**PROPOSED RESIDENTIAL DEVELOPMENT  
WADDOW VIEW, LAND OFF MILTON AVENUE, CLITHEROE**

**TRANSPORT ASSESSMENT**

Martin Nugent  
D3/11/0892

#### **Outline Planning Application, Ribble Valley District D3-11-0892 land off Milton Avenue, Clitheroe**

Appendix 2: Masterplan

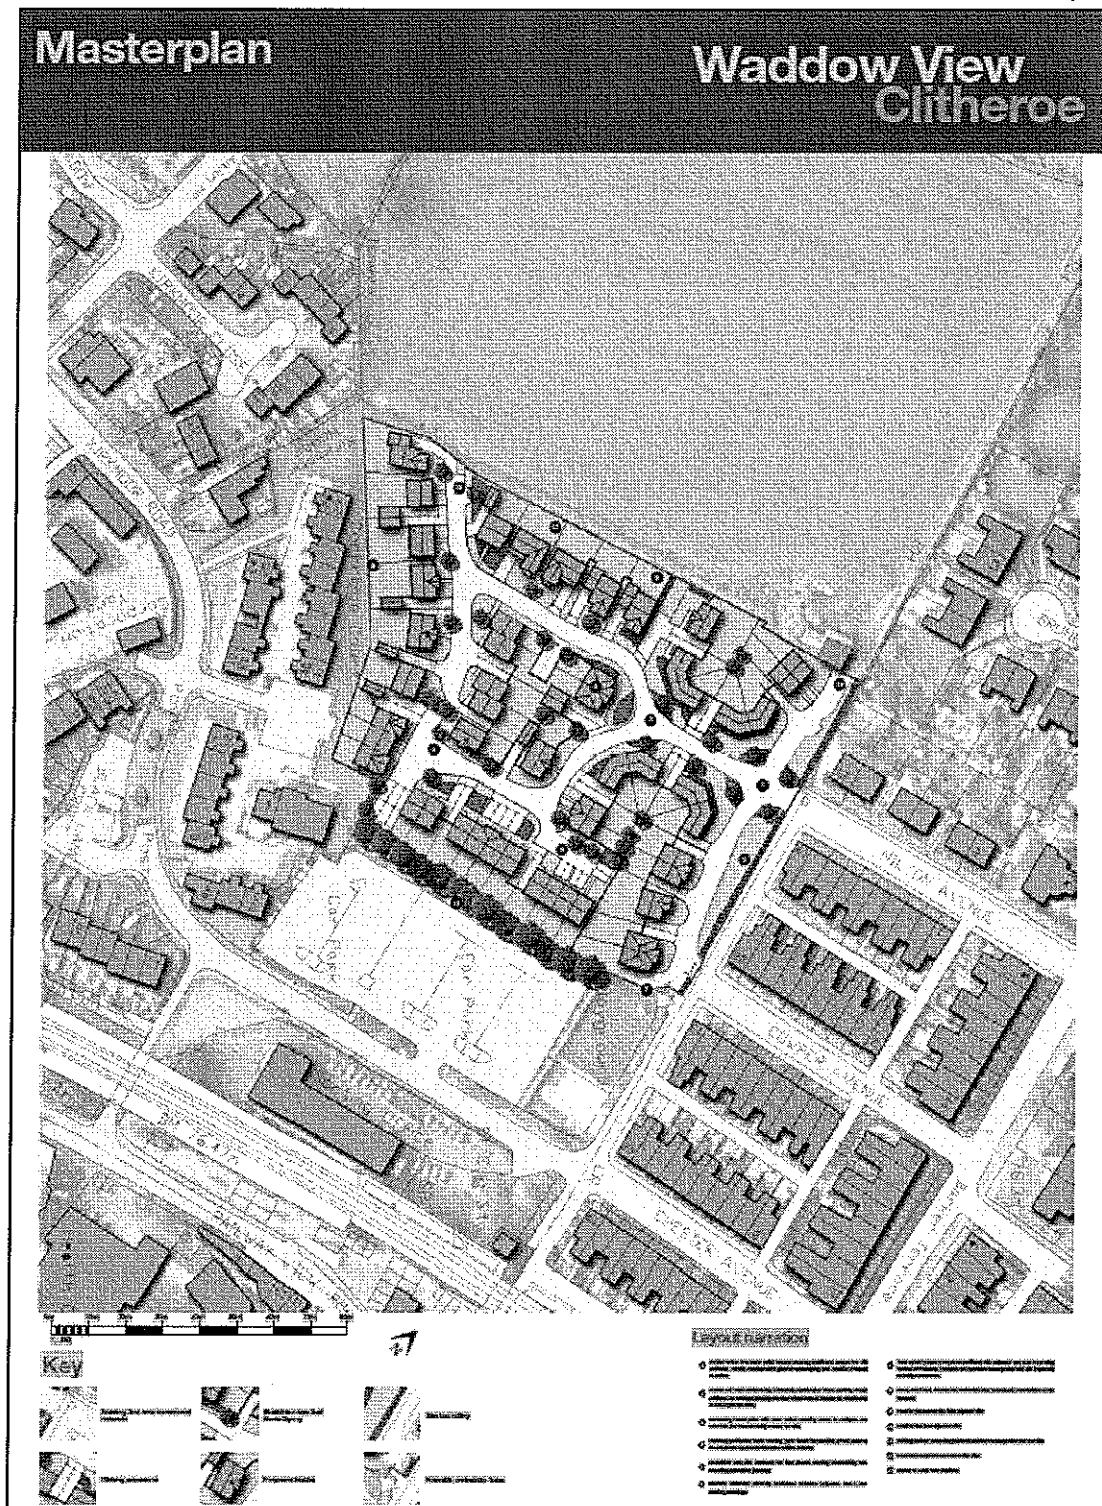
As the access road to the site extends south west from Milton Avenue, the existing road width should be maintained for a minimum distance of 10m into the site, with footways to either side. The site plan indicates that there will be no footway provision within the site.

Furthermore, the site plan indicates at Point 10, a "possible link into adjacent site". The layout shown, in terms of carriageway width and footway provisions, would not be suitable as a means of access to an additional area of development.

There is an existing agricultural use to the land immediately to the north of the proposed development, with access maintained through the site from Milton Avenue. The design of the first junction within the site must allow for the safe movement of any anticipated vehicles. As this land will allow for a range of permitted agricultural uses, any swept path modelling must include a variety of potential vehicles, such as tractors with a variety of trailers.

In relation to the pedestrian accessibility of the site, the site master plan identifies a possible footpath link between the development and Chester Avenue. However, this link would run along third party land and there are no legal agreements identified or suggested that would resolve this ownership issue. Without such a link there are no specific provisions to promote pedestrian access to this site.

**Although the above points could be dealt with unreserved matters all the above points were dealt with by an amended plan showing footpaths, increased widths and an access for the farm track if required.**
